Consultation Response from KC Highways Development Management		
2026/90791 350, Huddersfield Road, Mirfield, WF14 9DQ		
Change of use of furniture manufacturer and upholsterer to mixed-use site comprising ground floor retail E(a) and café E(b) and first floor acting / education class F1(a) including theatre and dance hall (sui generis)		
Date Responded: 17/07/26	Responding Officer: M Zenner	Responding Ref: 10-6SW/31

RECOMMENDATION: HDM objects to the proposals as follows:

PROJECT TITLE			
MIRFIELD LITTLE THEATRE			
DRAWING TITLE			
General Arrangement GROUND & FIRST FLOOR			
SCALE	DRAWN	CHECKED	PROJECT REP
1:50 at A1	dn	Lou	0178
PAPER SIZE	DWG NUMBER	DATE	REVISION
A1	(20)002	March 26	B
CLIENT DETAILS			
MIRFIELD LITTLE THEATRE

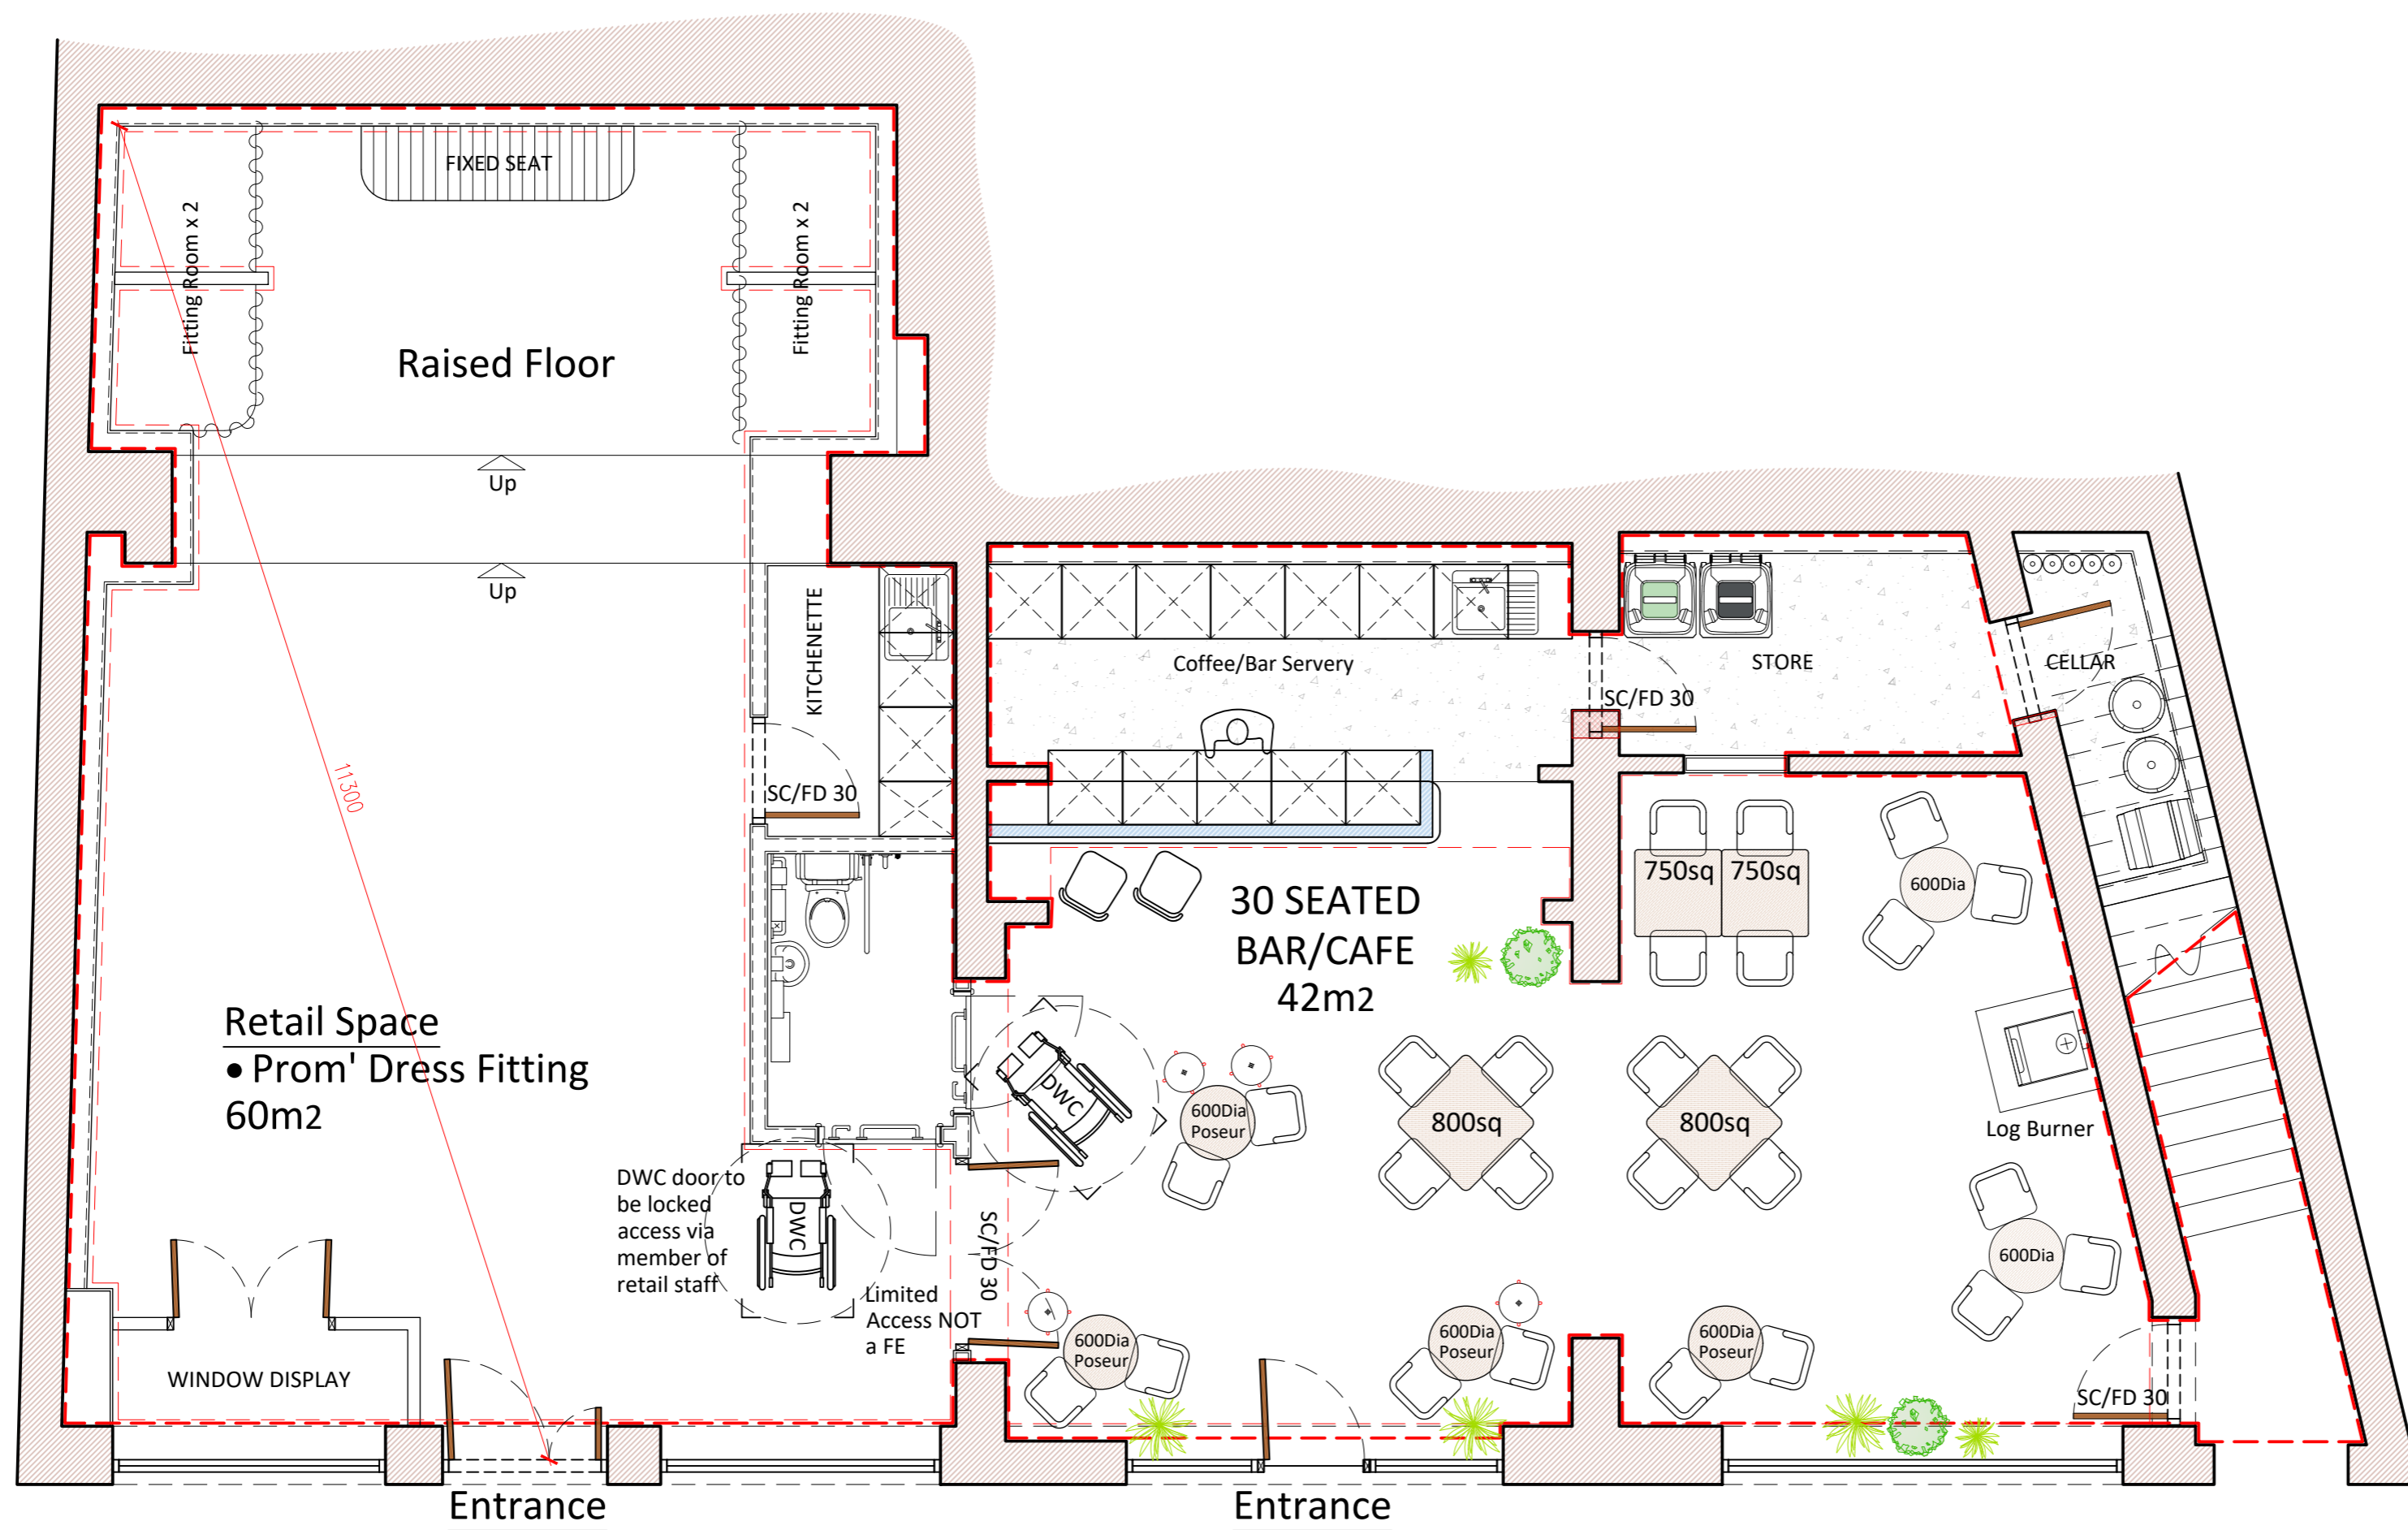
HDM previously requested clarification over the access arrangements at the site, the supplementary information provided states that customers will access via Huddersfield Road unless they require accessible access for the first floor theatre, which they state is provided via Back Lane, however no detail is provided as to how visitors will be aware of these arrangements.

Staff are stated to access via Huddersfield Road. The submitted information states that staff numbers are low with typically 1-2 per use, but does not provide a total number within the submission which should be provided.

HDM requested further information on servicing and waste management and the applicant has confirmed that 95% of deliveries will be taken at the front on Huddersfield Road with 5% using the rear loading bay use. The details provided seem light on detail and HDM is concerned that the applicant is assuming that the frontage on Huddersfield Road will have available parking, as it is public highway this may not be the case.

In terms of waste management the applicant states that the existing bin storage will be retained, but there is no evaluation / information of whether this is adequate to service the range of uses outlined which includes a café.

No information has been provided in relation to the likely car parking demands and cycle parking demands at the site and no provision has been made for the needs of people with disabilities. No off-street car parking, cycle parking or accessible parking has been provided as part of the proposals.

The existing pedestrian access points to the site are not proposed to change as part of the proposals, however, the submission states for theatre use accessible access is available from Back Lane. It is unclear how this will be evident to visitors to the site who may not have visited before.
